12405 OREGON WAGON TRL  
PARCEL 42170-04-028  
PLAT 8096 RR-2.5 2.69 ACRES  
LOT 89 THE TRAILS FIL NO 2

AG2145

Customer: Jennifer LaCoe Delivery Address: 12405 Oregon Wagon Trail  
Elbert, CO

Date: 9/27/21 Phone: 845-541-8847 Email: jennlacoe@gmail.com Referred By:  
Depth: 12 Roof: Tan Body: Ivory Trim: Tan #  
Width: 40 Height: Standard Model: Carriage House Price 27,775.00

Date: 9/27/21 Phone: 845-541-8847 Email: jennlacoe@gmail.com Referred By: _____
Depth: 12 Roof: Tan Body: Ivory Trim: Tan # _____
Width: 40 Height: Standard Model: Carriage House Price 27,775.00

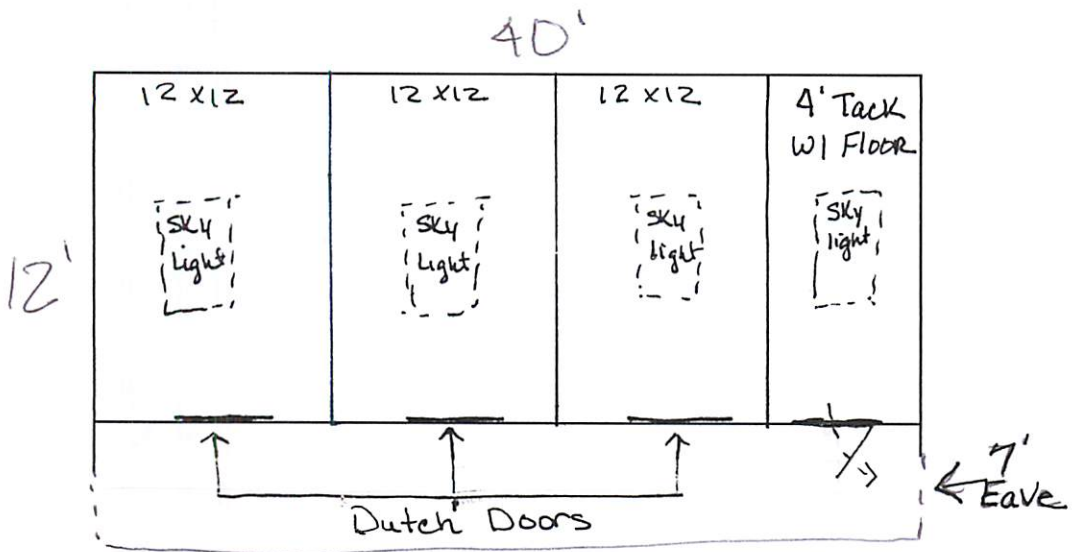
Provide engineer stamped plans for the metal building. A design professional stamped soils report and foundation design must be provided to the building inspector at the first inspection.
